Application Reference: 2025/0785.

Location: 4 Whinmoor View, Silkstone, Barnsley, S75 4LL.

This application seeks planning permission for the erection of a raised patio extension to an existing rear extension erected as permitted development.

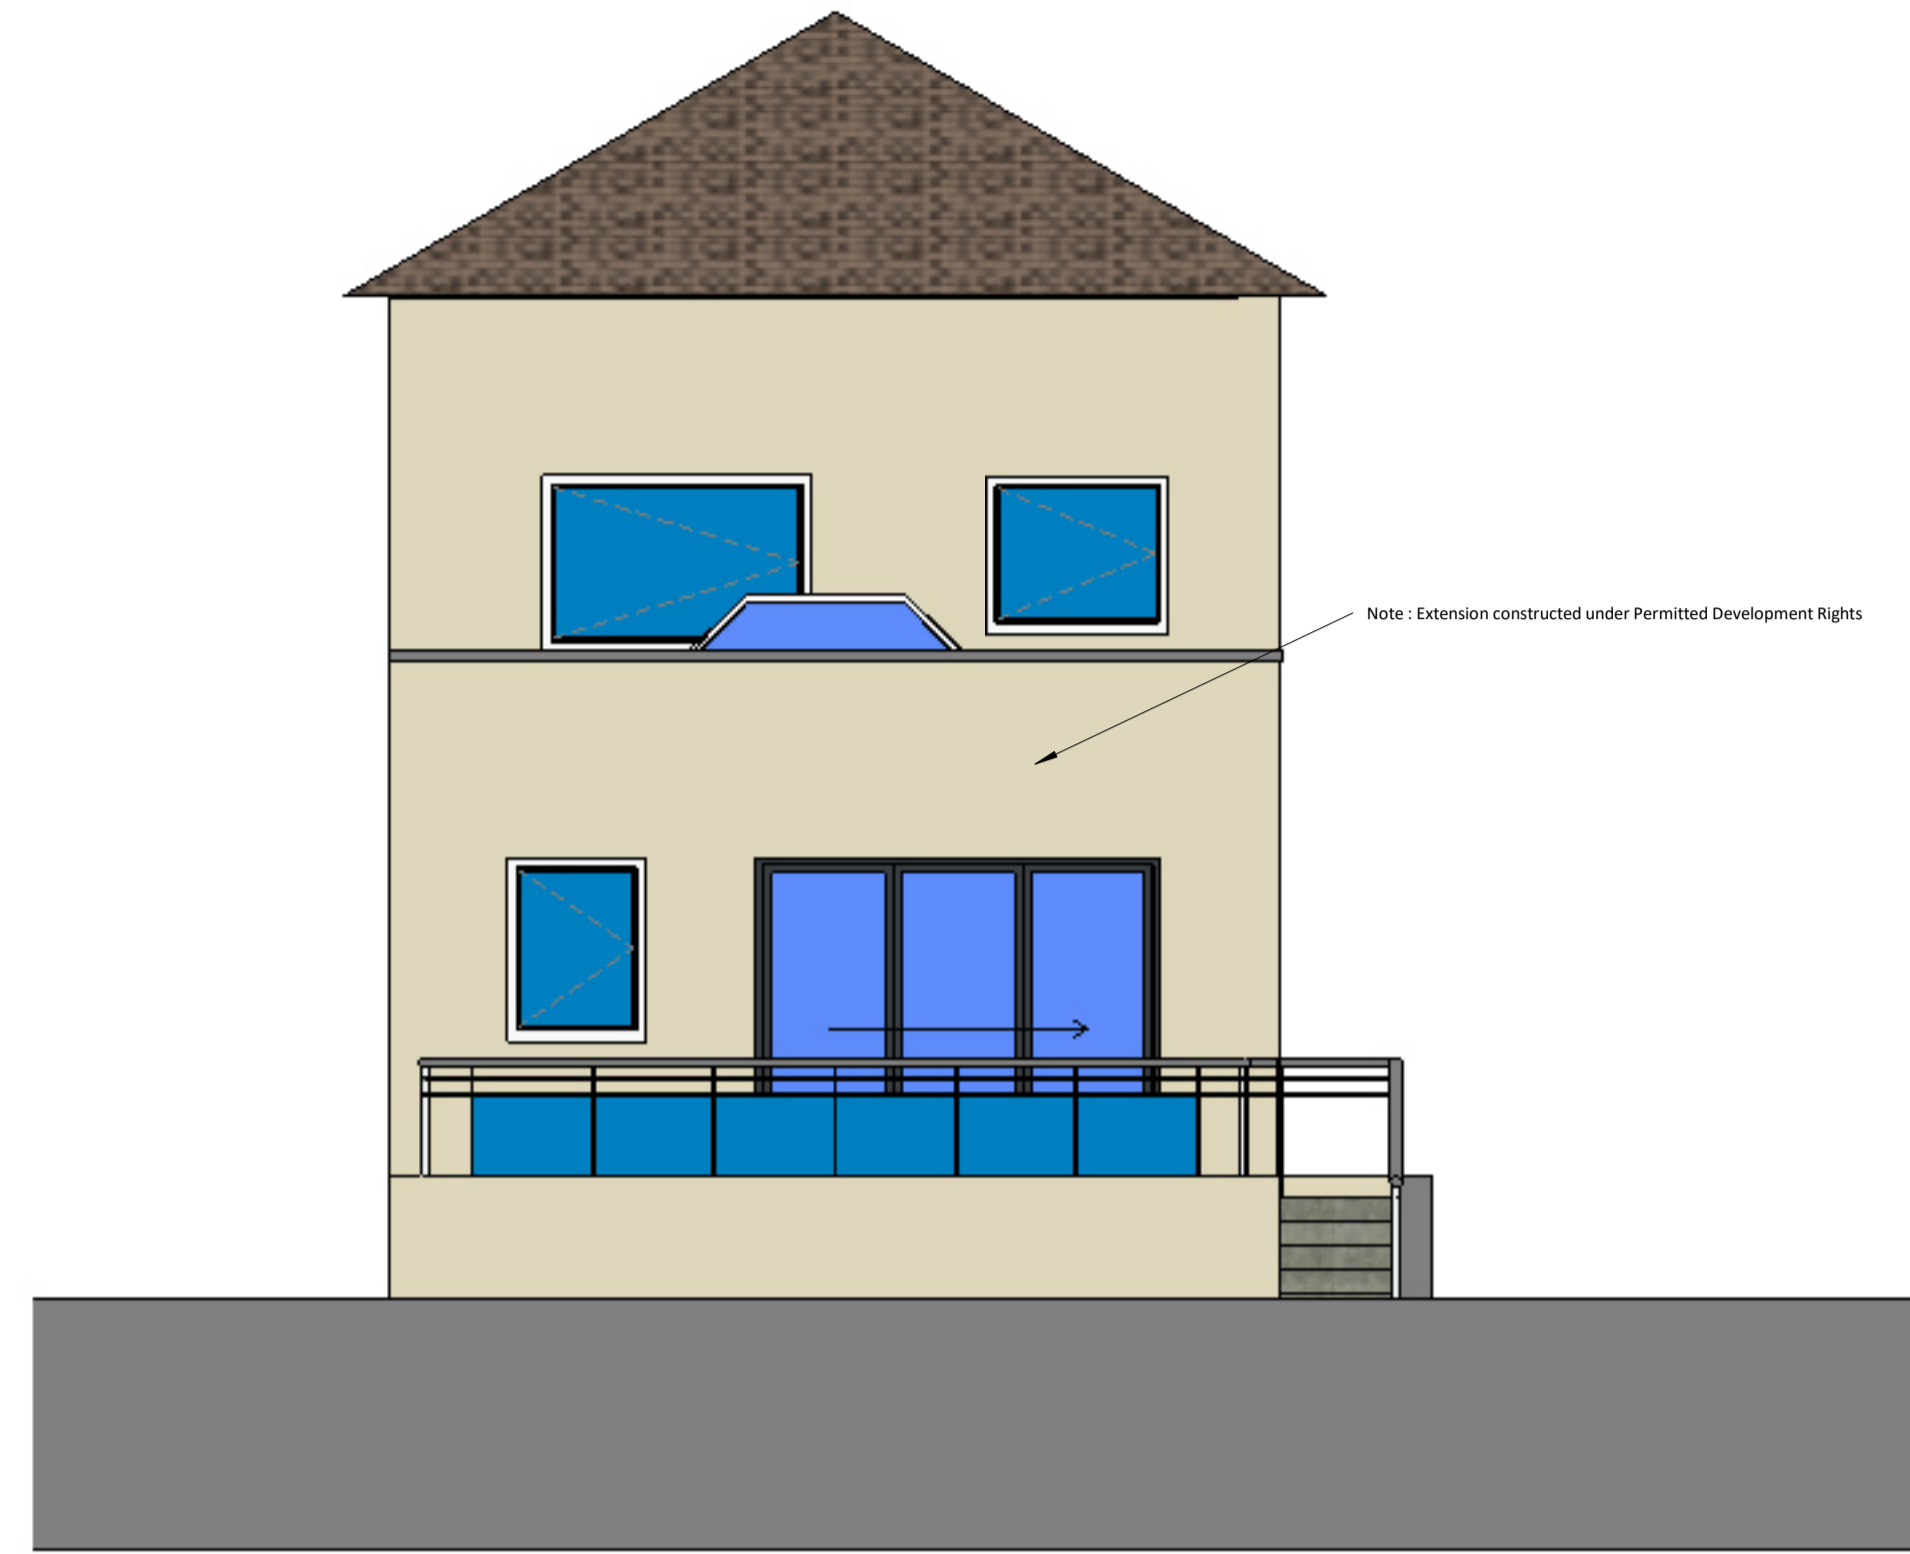
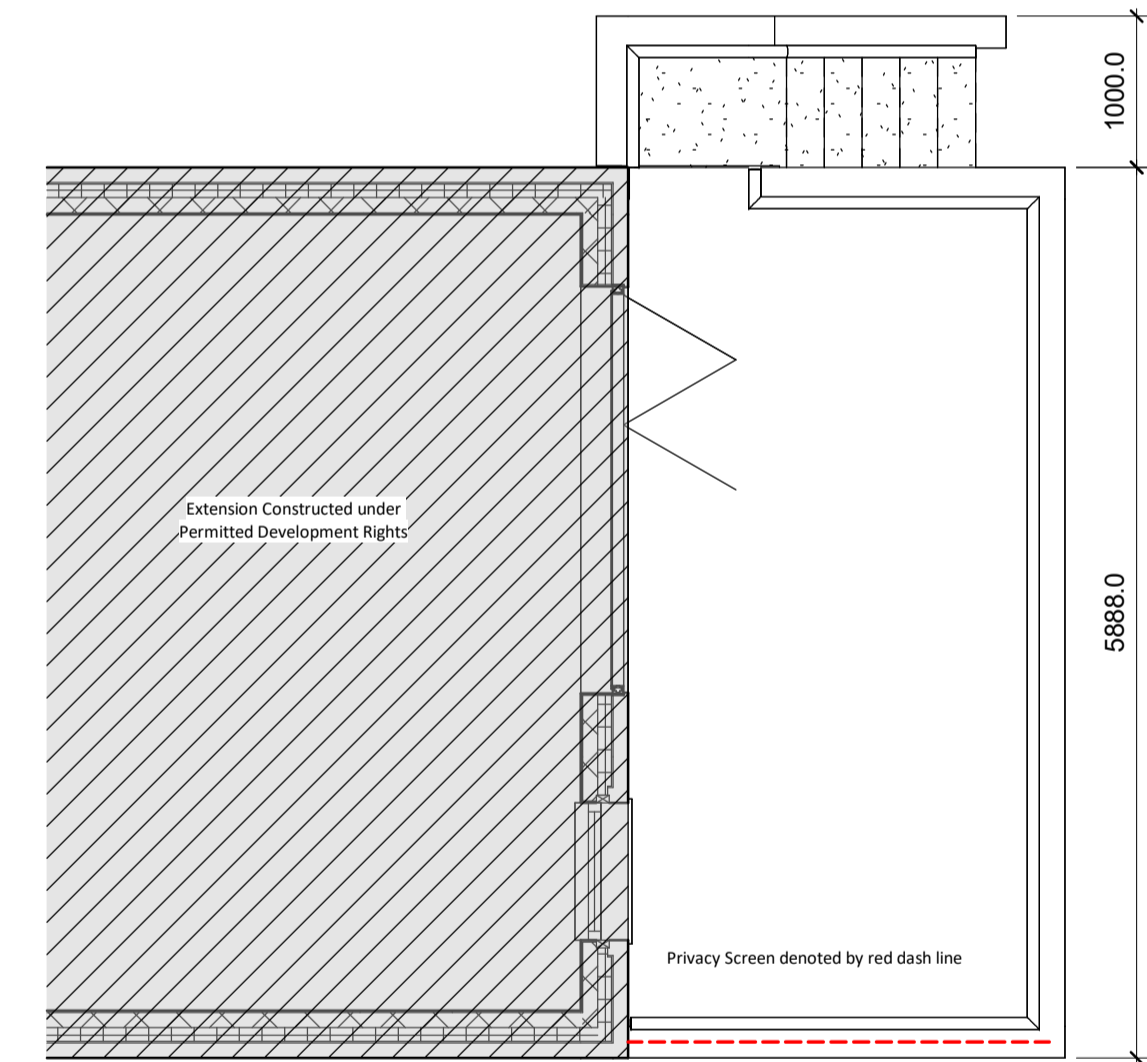
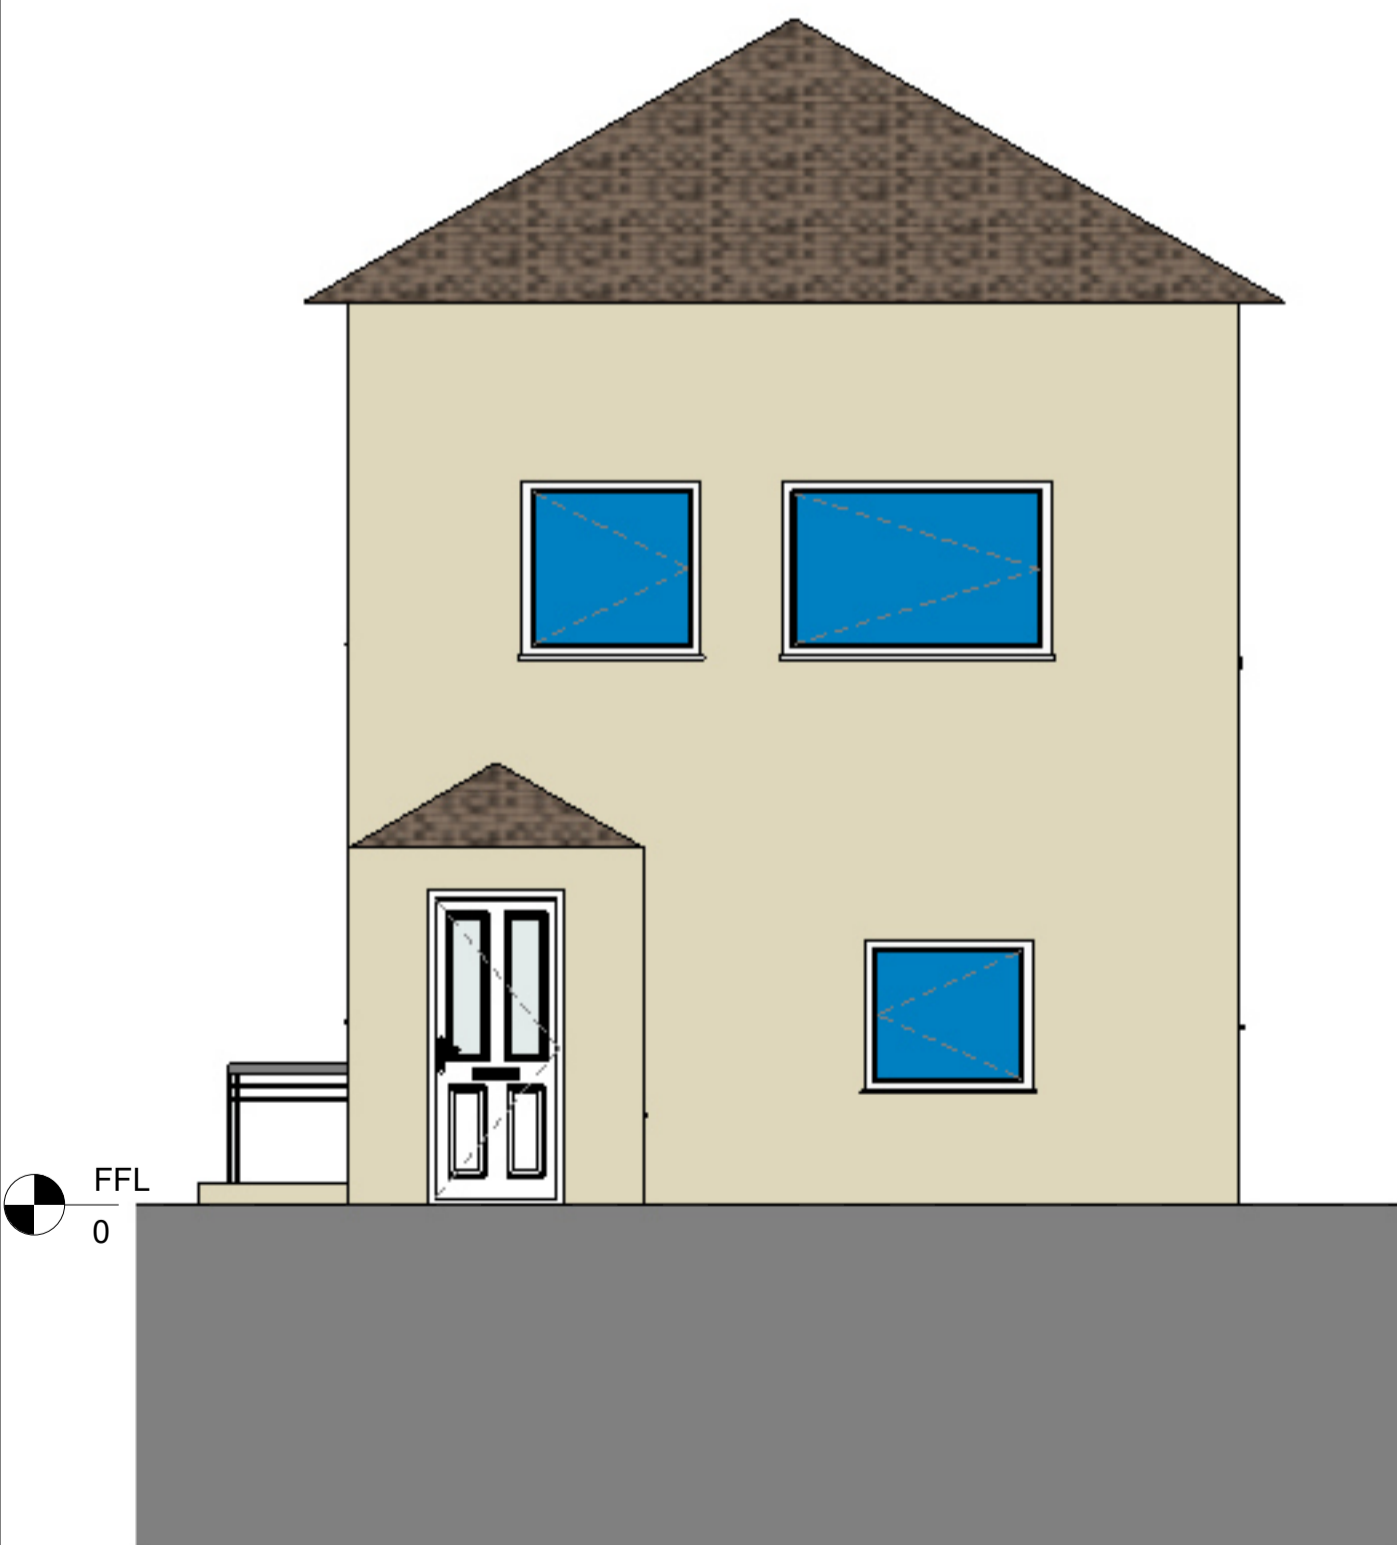
A 1.8-metre-high privacy screen is proposed on the south-east side of the raised platform. While this is shown as a trellis-like screen on the submitted plans following discussions with the Applicant it is understood that a solid composite screen (or similar) would be erected. For the avoidance of doubt a solid screen could be secured by condition should this application be approved.

Notwithstanding the above, potential amendments were suggested by the LPA to the Applicant such as setting the raised platform and privacy screen in from the side elevations of the rear extension to the application dwelling and re-locating the steps to the rear. A height reduction was also considered by the LPA. However, the Applicant decided to proceed with the application as submitted and without amendment. The LPA cannot enforce amendments upon the Applicant and therefore must consider the proposal as submitted.

- Amendments were sought to provide a set in from the side elevations of the rear extension, the re-location of steps to the rear and additional screening. The Applicant decided to proceed with the application as submitted and without amendment.
